Your Ref: OWPC20973
Our Ref: A/158/18/PL 23-11-2018
Please ask for:
Mrs A Gardner

Variation of condition 1 imposed under A/8/18/PL relating to the substitution of approved plan drawings NO ADC 962 04 rev A & 13 rev B for drawings No ADC 962 20 & 21 (ground & first floor plans & roof plan). This application affects the character & appearance of the Angmering Conservation Area.

Land Rear Of 1 To 6 The Cottrells Angmering

Rev	Description	Date
Job Reference		
New House The Cottrells Angmering, BN16 4AF		Client AM Homes Ltd
Drawing Title Ground Floor Plan		Drawing No ADC962/20
Date 23.11.18	Scale 1:100	Dwg Size A3
Plot Style ADC-red	Drawn TOS	Checked AD

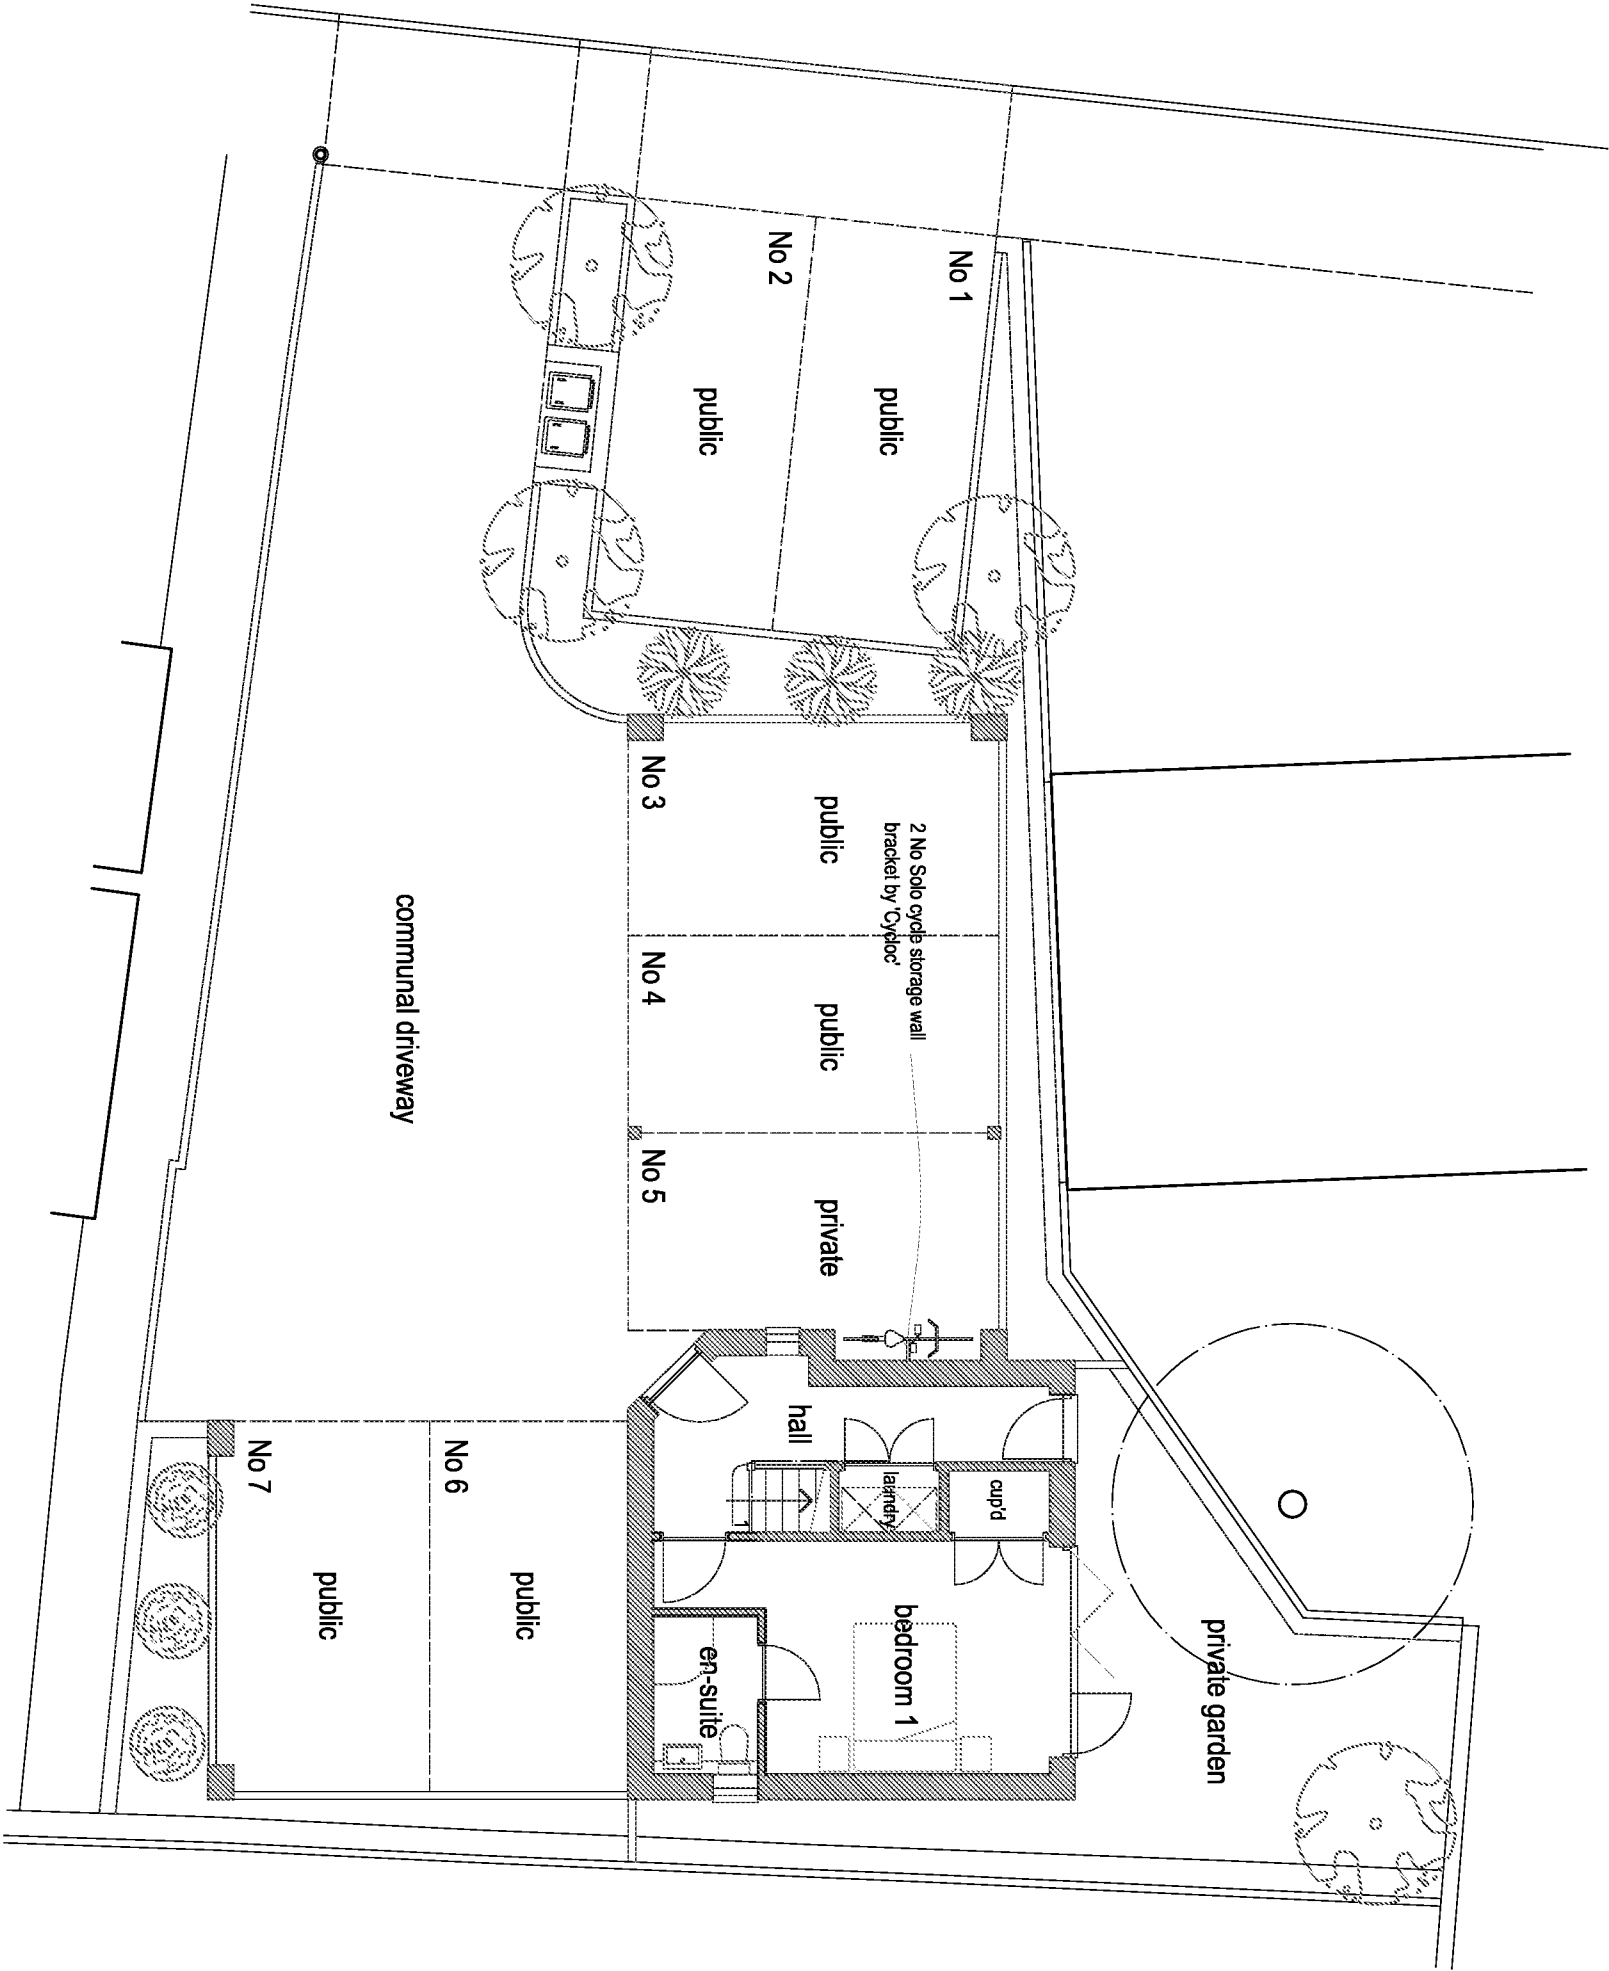
- 5. The internal reconfiguration allows for the potential re-purposing of the rooms from a study and 2 bedrooms to 3 bedrooms. Indeed on previous plans the 'study' has always been 'bedroom 1 or master bedroom'.*

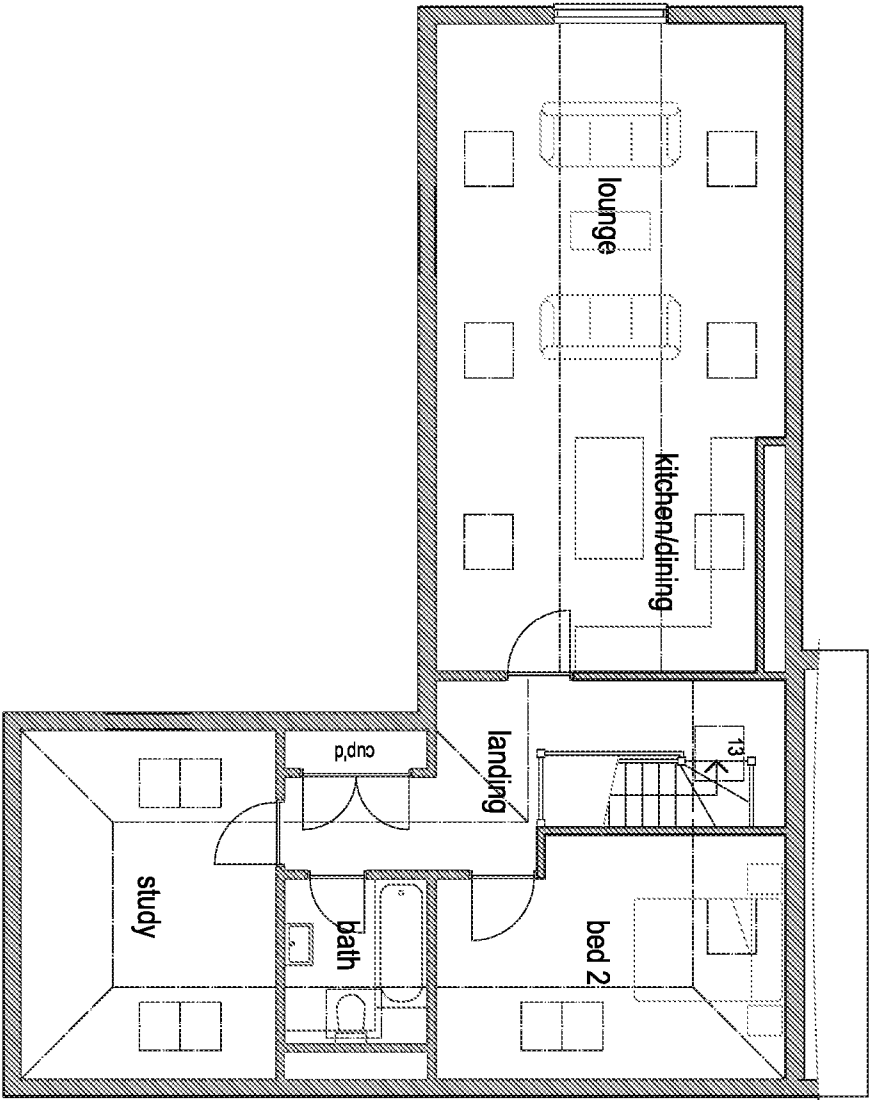
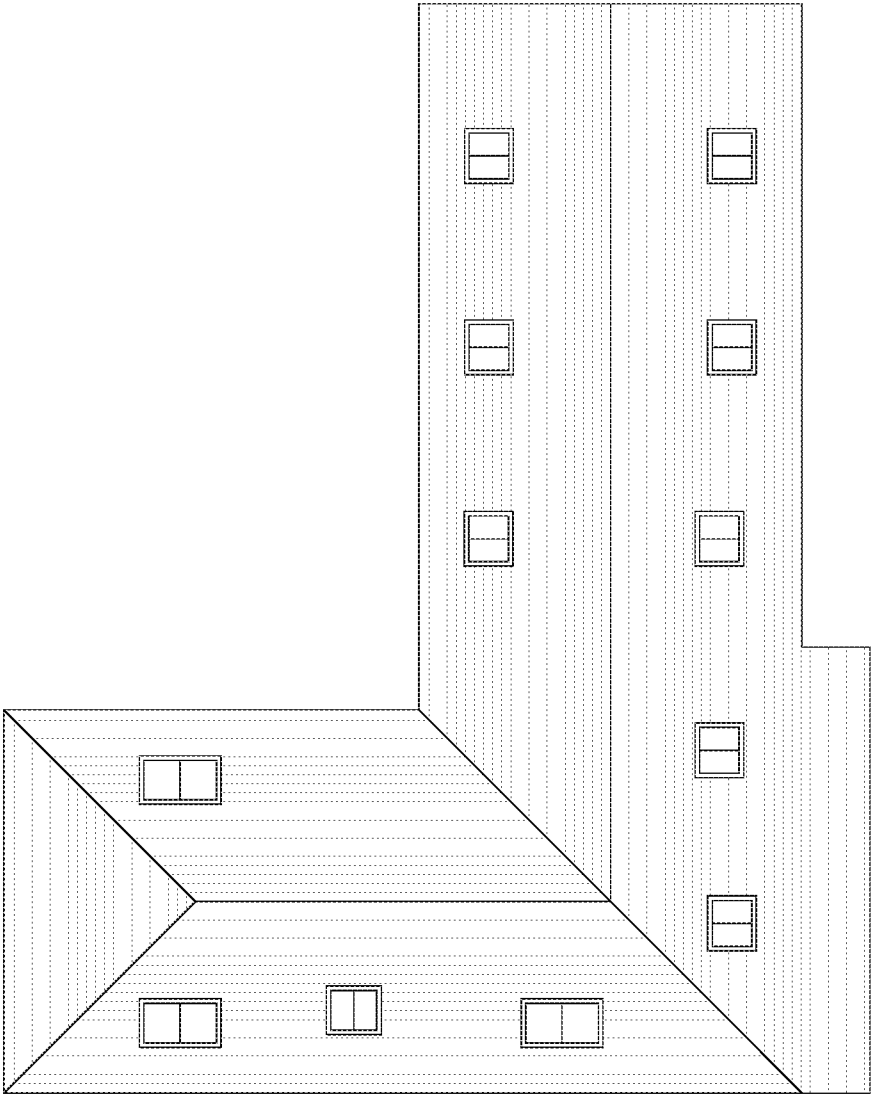
9. The windows on the approved plans are emergency roof lights installed higher up the roof than the windows currently installed. This was to protect the privacy of both the occupiers and neighbouring properties - the installed windows do not provide such privacy
